## Application for a Non-Material Amendment Following a Grant of Planning Permission

We have recently been given planning permission to do a renovation on the property to do a garage conversion and a 1st floor extension. We have decided to rather make the garage conversion a flat roof, instead of a pitch roof that was originally included in our plans.

Drawing Title
 Proposed Roof Plan - Approved

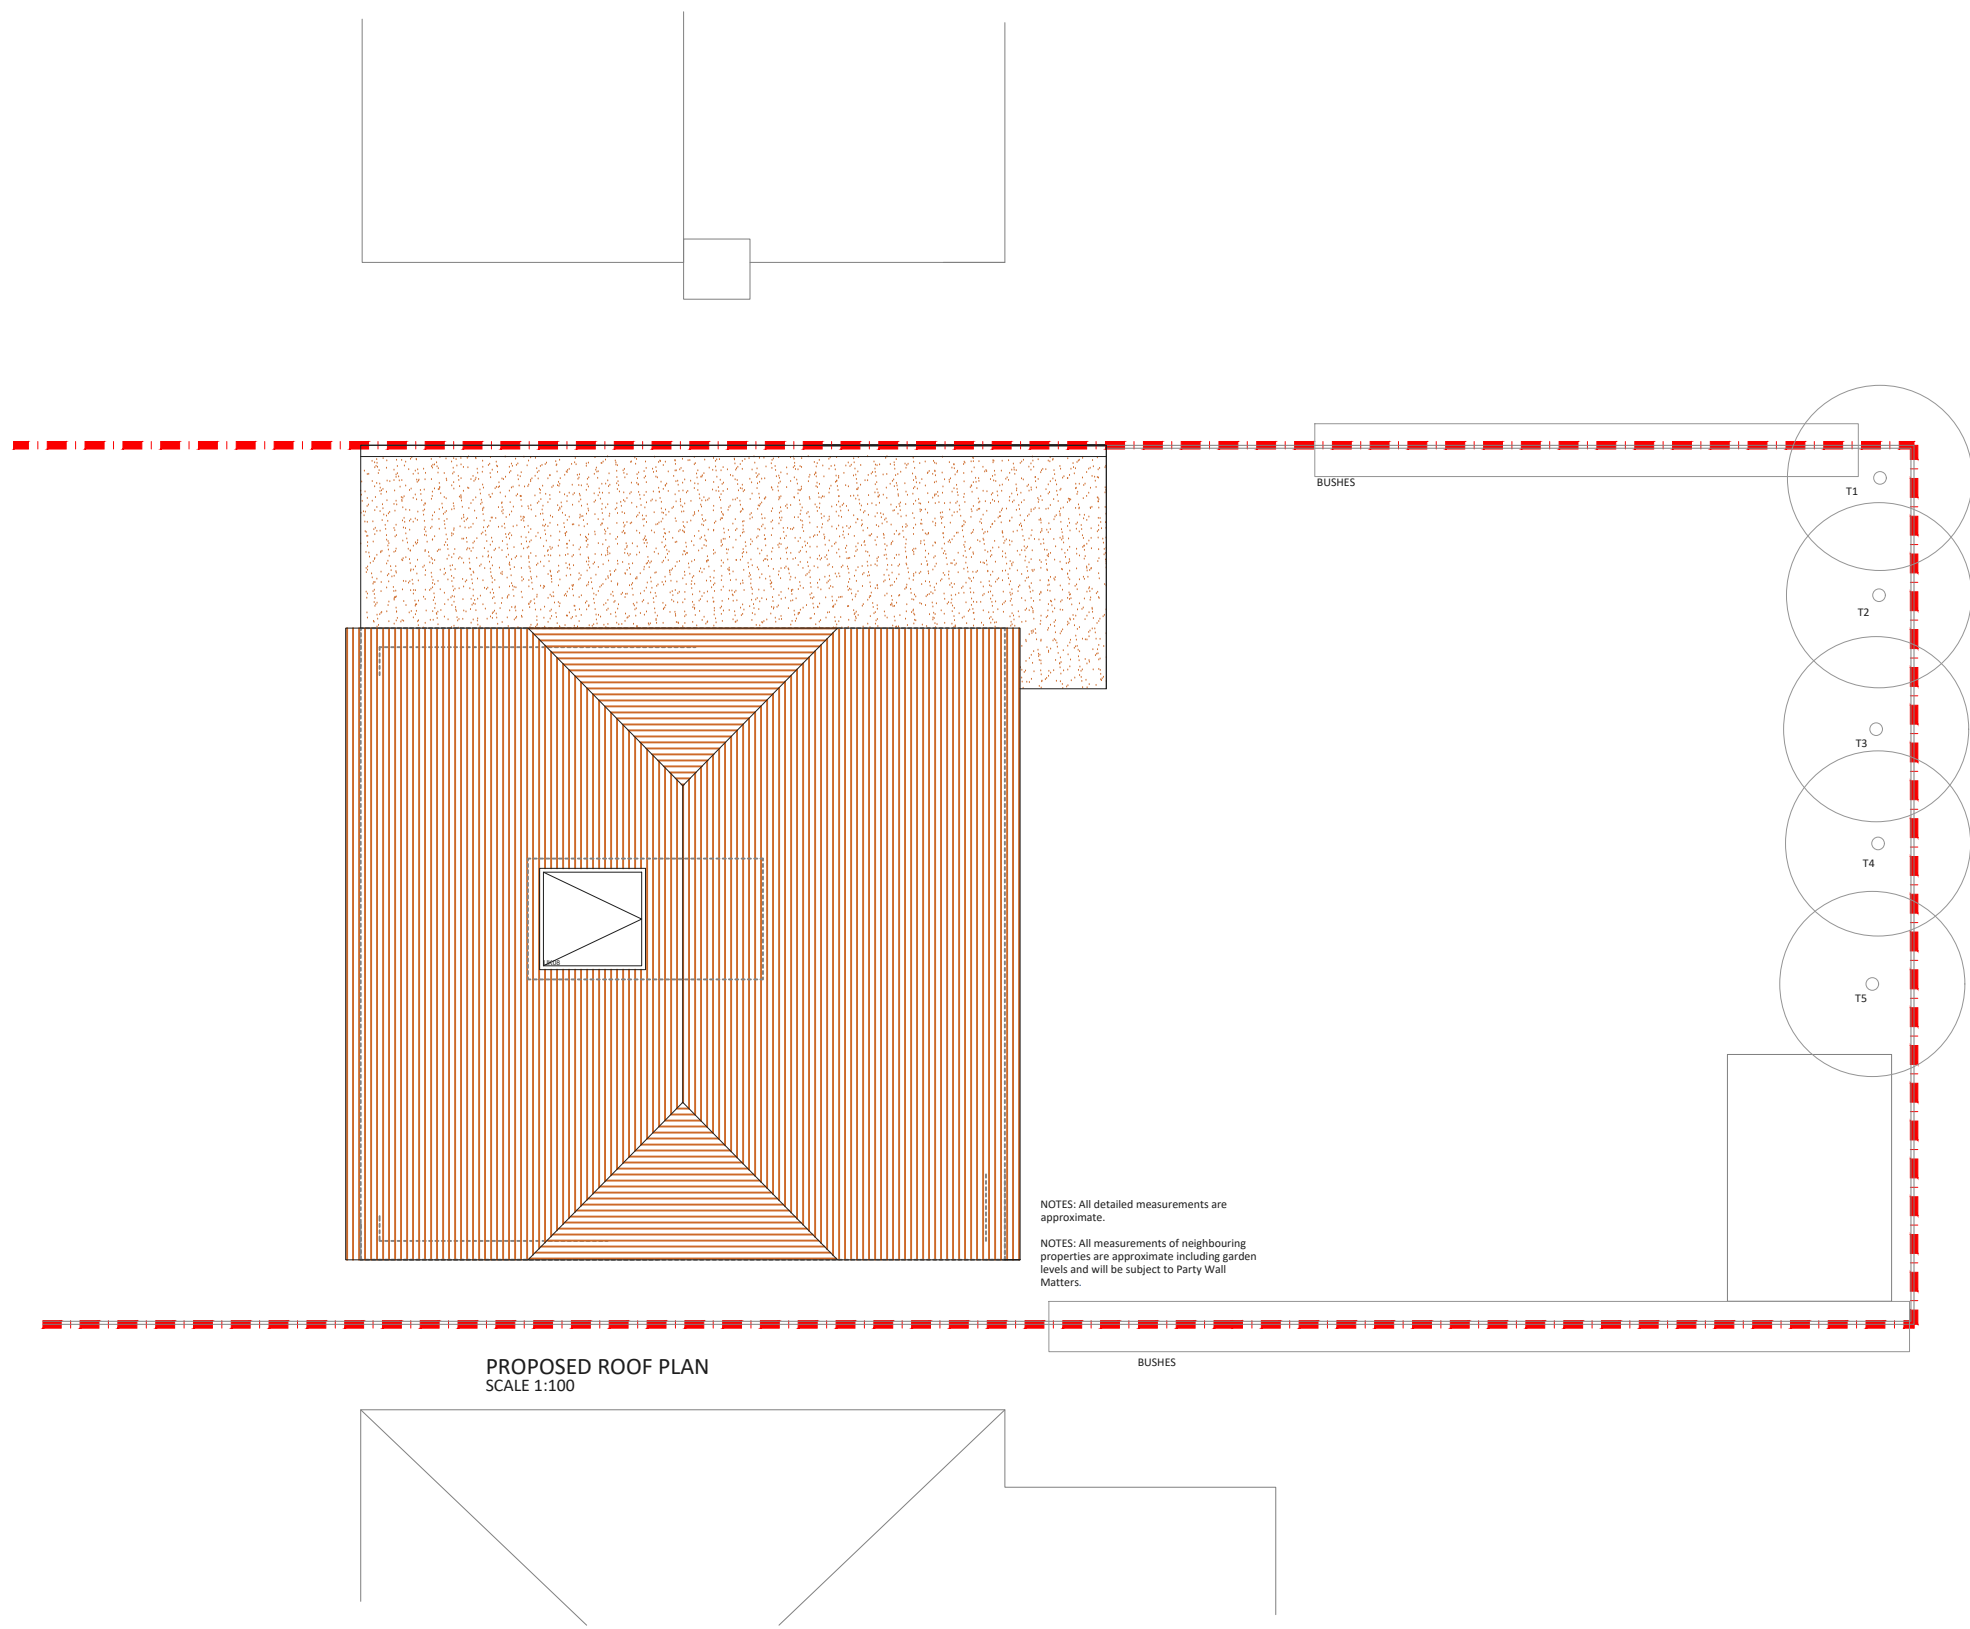
This will therefore make the garage roof at that same level as the current kitchen roof. This change will not affect the height of the current kitchen roof.
